Re: Status of Permit Application-BRES2408-0037

An attempt was made to evaluate your property for issuing an Improvement Permit. The evaluation could not be completed for one or more of the following reasons.

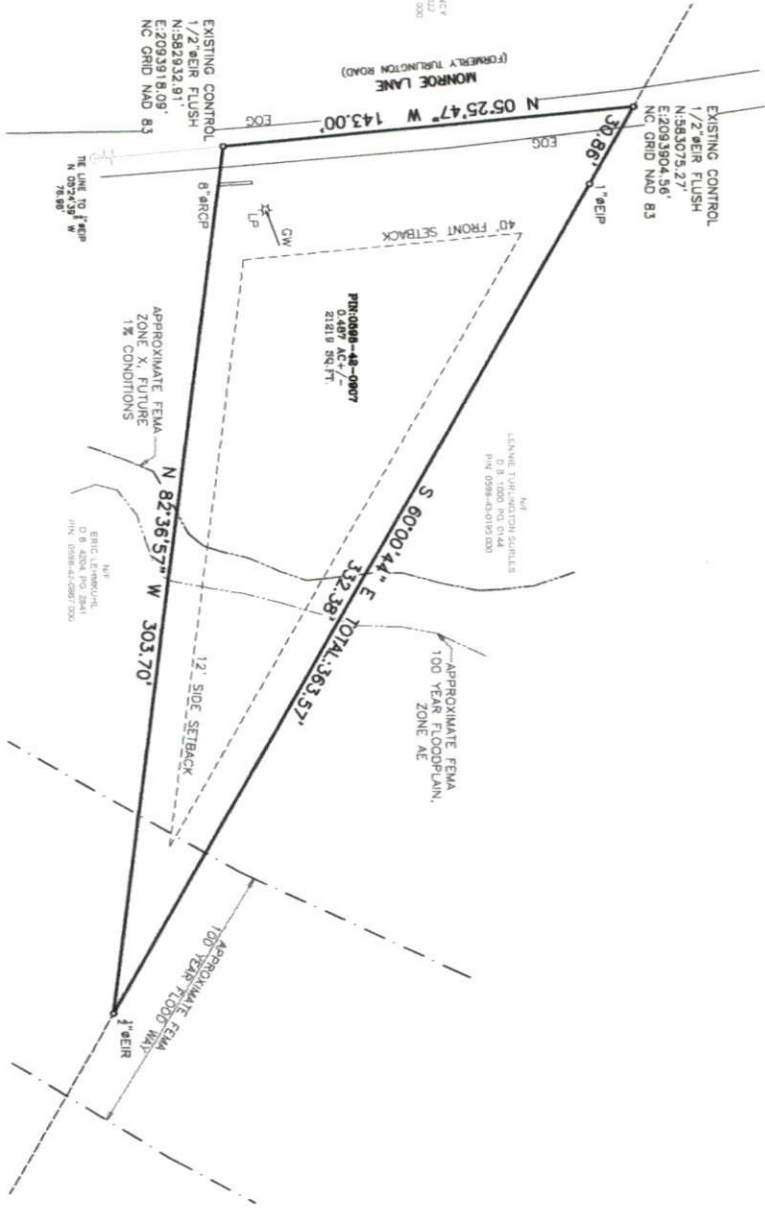
- 3. Directions not clear to property (\$25.00 fee incurred)
- 4. Clear Vegetation. Do not disturb the soil.
- 5. Driveway not shown on site plan
- 6. Backhoe Pits Required-

- 7. **Other- Update site plan with DW setback/measurements to property lines. Must place DW as close to the front property line as possible. Make sure the back left corner of the DW is 10' from the right property line as if you were standing on the road. Must move driveway slightly over 10' to the right as if you were standing from the road. May be required to have duke move your power line to front right corner of property to allow room for DW. Well area was changed to front right of property. Application needs to be revised to 2 bedroom at Central Permitting.**
